City of Sydney

1 March 2012

Our Ref: 2012/058995
File No: R/2012/2
Your Ref: MP06_0101 MOD 1 & MP11_0093

PEMULWUY MIXED USE DEVELOPMENT, REDFERN - MP06_0101 MOD 1 & MP11_0093

Eveleigh Street

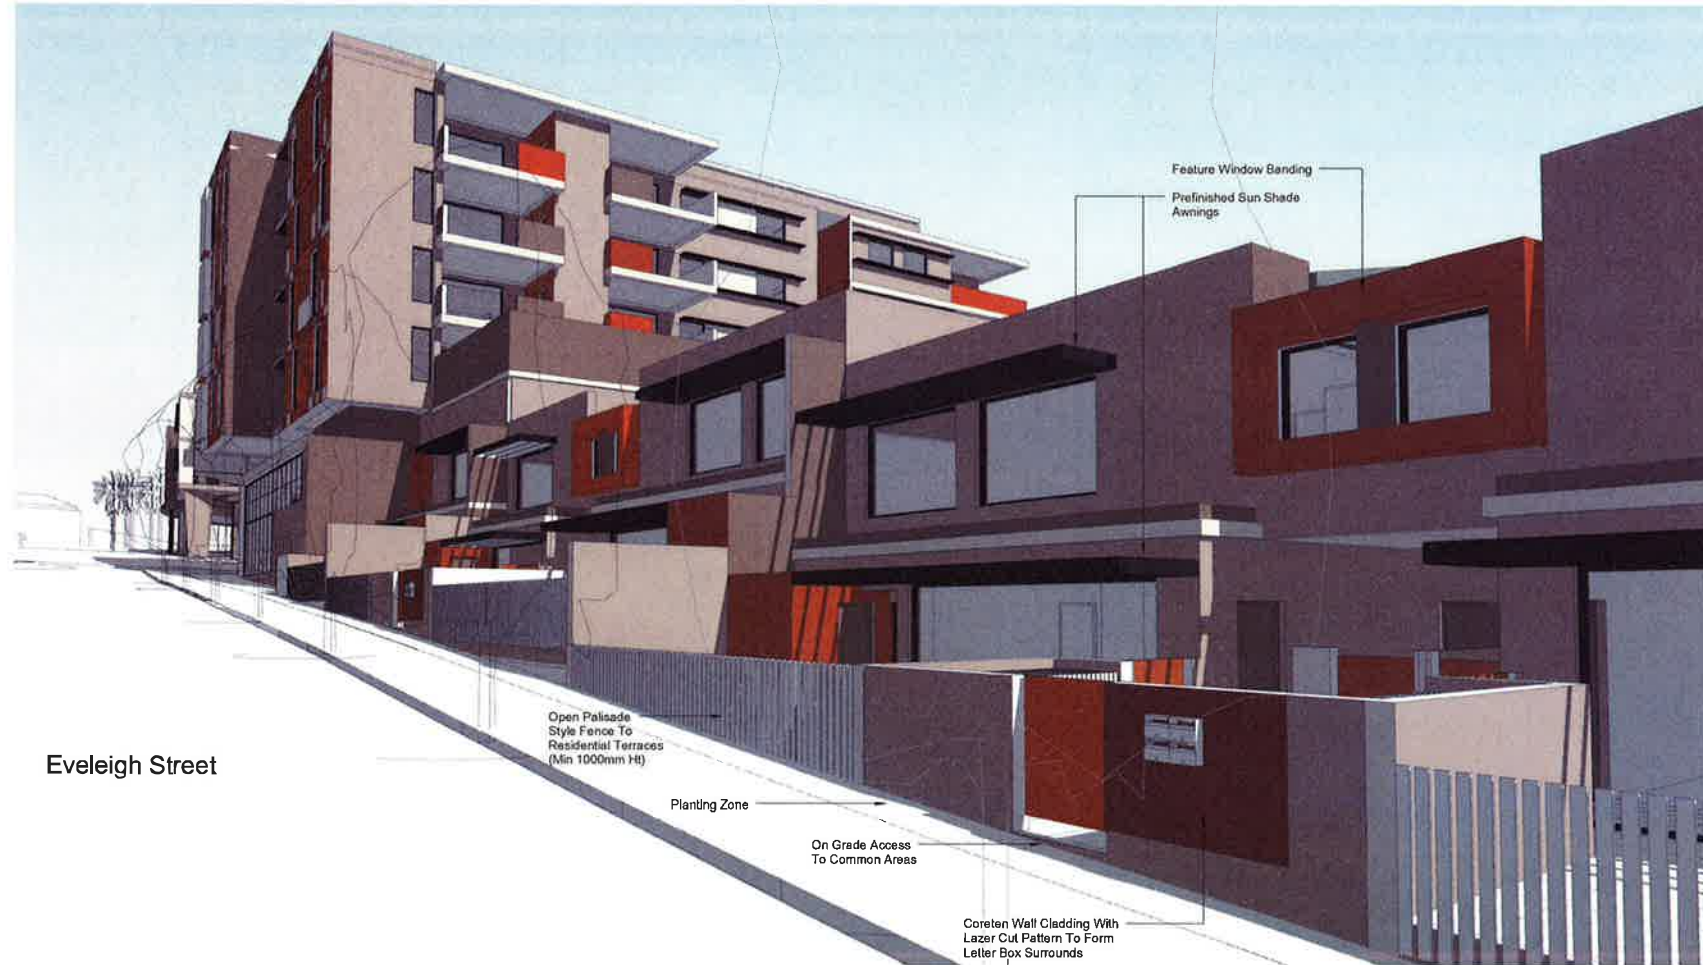
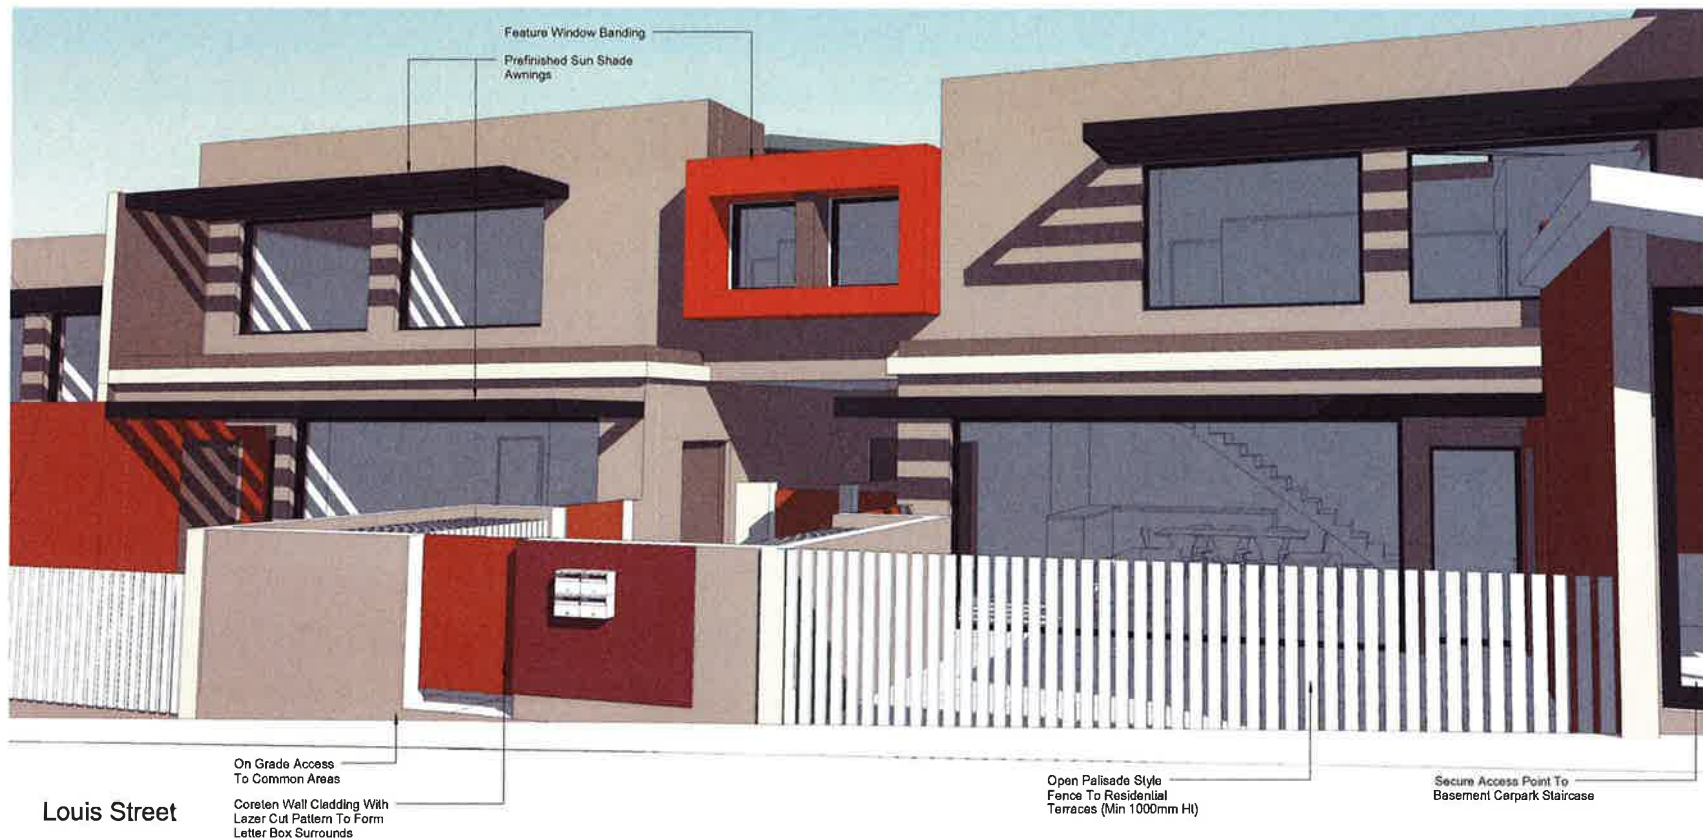
- The fenestration and facade design of the townhouses could respond better to their orientation. The windows along the south-east (Eveleigh Street) elevation are treated exactly the same way as the north-west (Louis Street) elevation. These elevations should be amended to provide appropriate vertical screening to west-facing windows to allow passive control of the low afternoon sun.

- Greater differentiation between the design of the Eveleigh Street and Louis Street elevations could create an improved sense of identity and address for residents. This could be achieved by introducing passive solar design measures as described previously.

1.1 Bridge Level
1:250

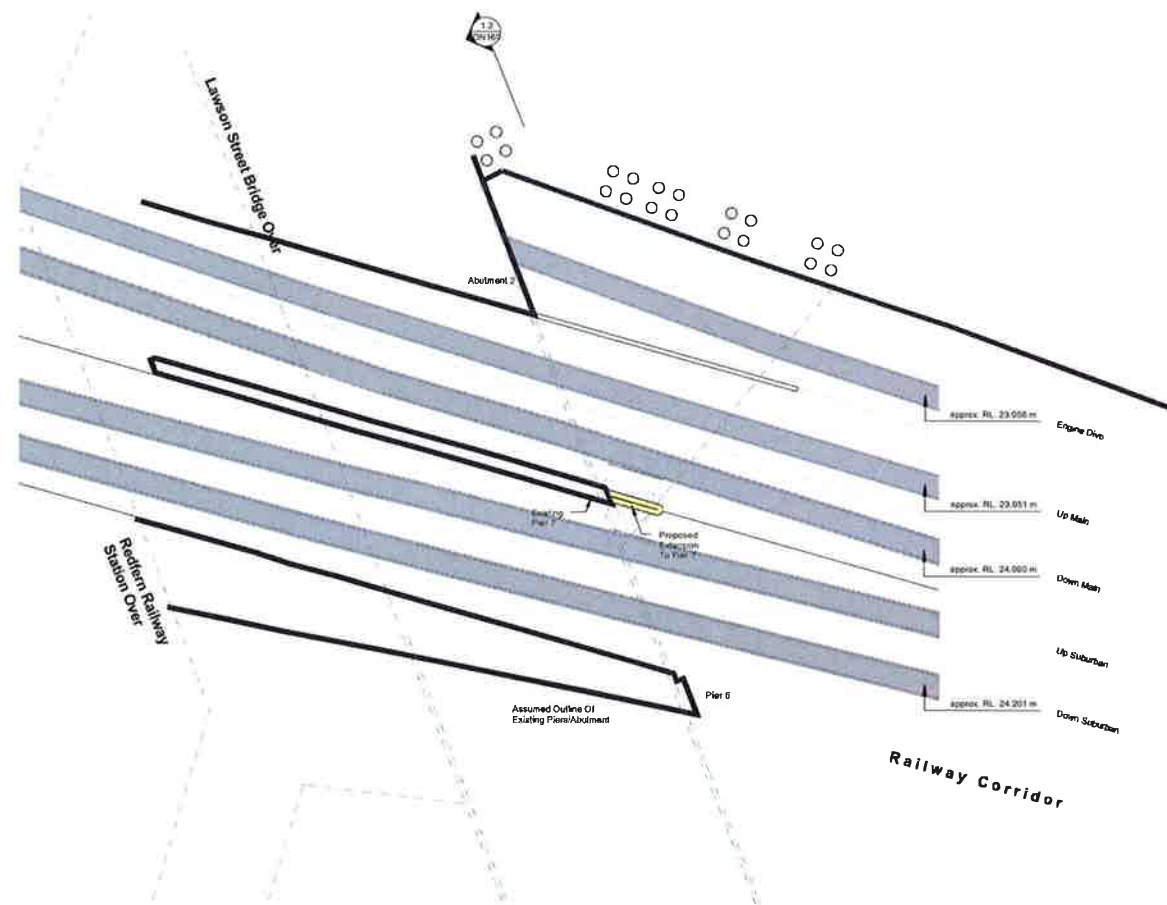
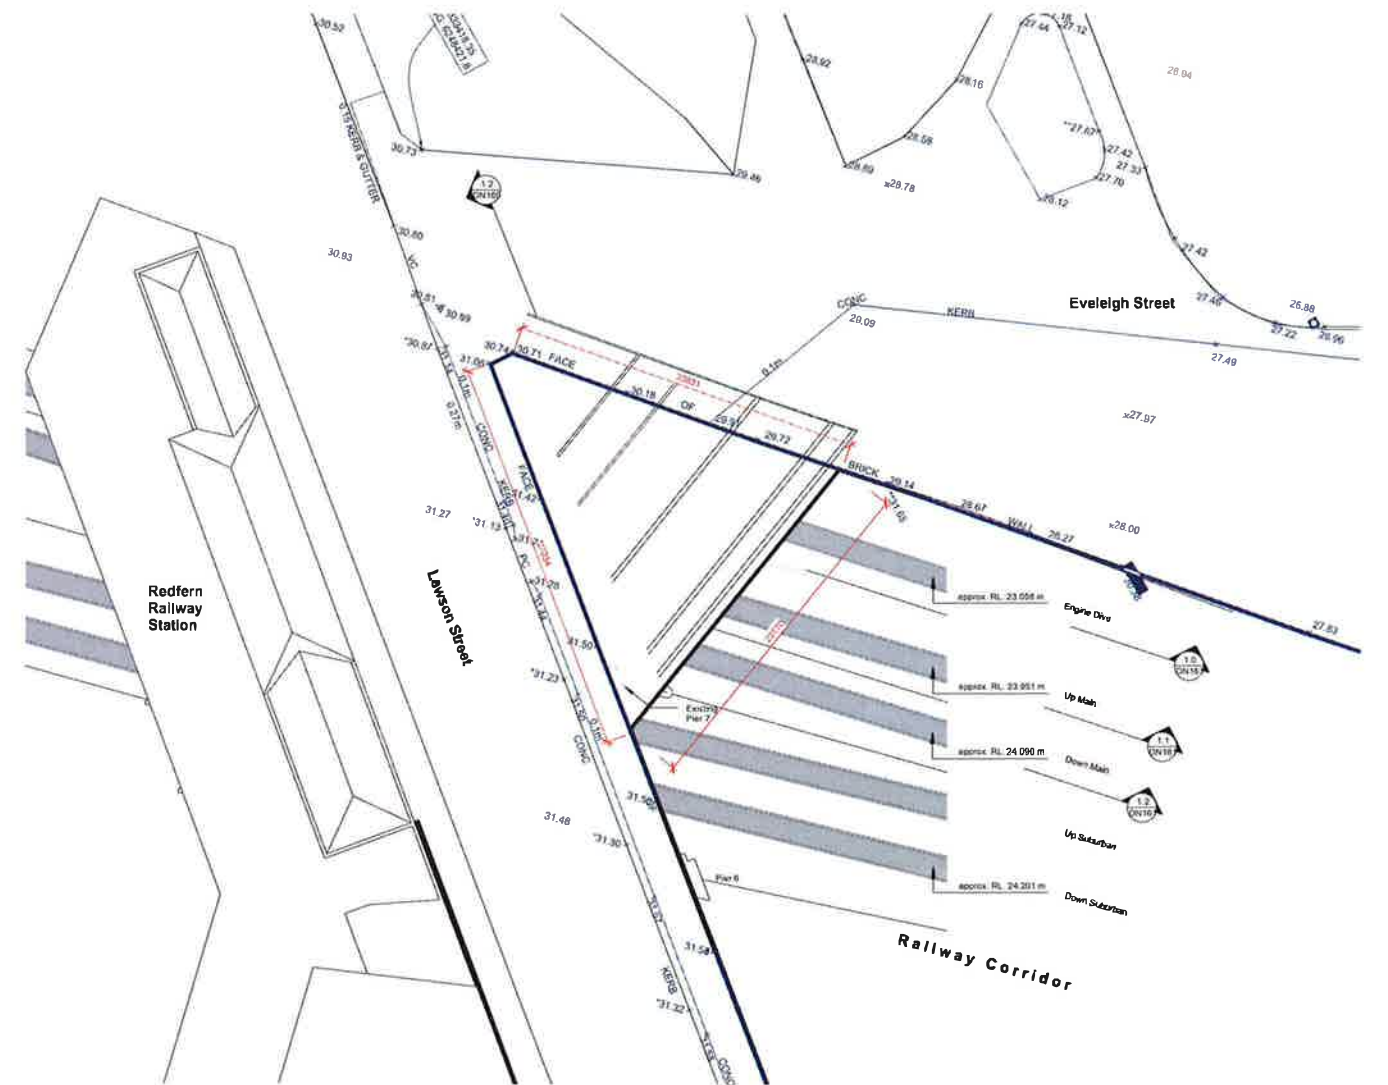
- While the improved pedestrian link and visual links created by the bridge are supported, concern is raised over the ownership issues surrounding dedication, ownership and access to the proposed land bridge. In particular the issue of ownership and stratum, where control by Railcorp ends and that of the City begins, and responsibility and liabilities for maintenance and rights for access have been raised previously.

- If these issues can be resolved satisfactorily, the issue of suitable materials for use and barriers above the walkway is raised. The use of granite is not supported as the Sydney Street Design code requires the use of either asphalt or concrete pavers. The land bridge, although a key component of the opening up of pedestrian and visual links across the site, is not a significant space in its own right that warrants the use of natural stone when it doesn't feature in other more significant areas of the design. The applicant is requested to review the Sydney Street Design Code for the relevant materials appropriate to the location and intended use of the space.
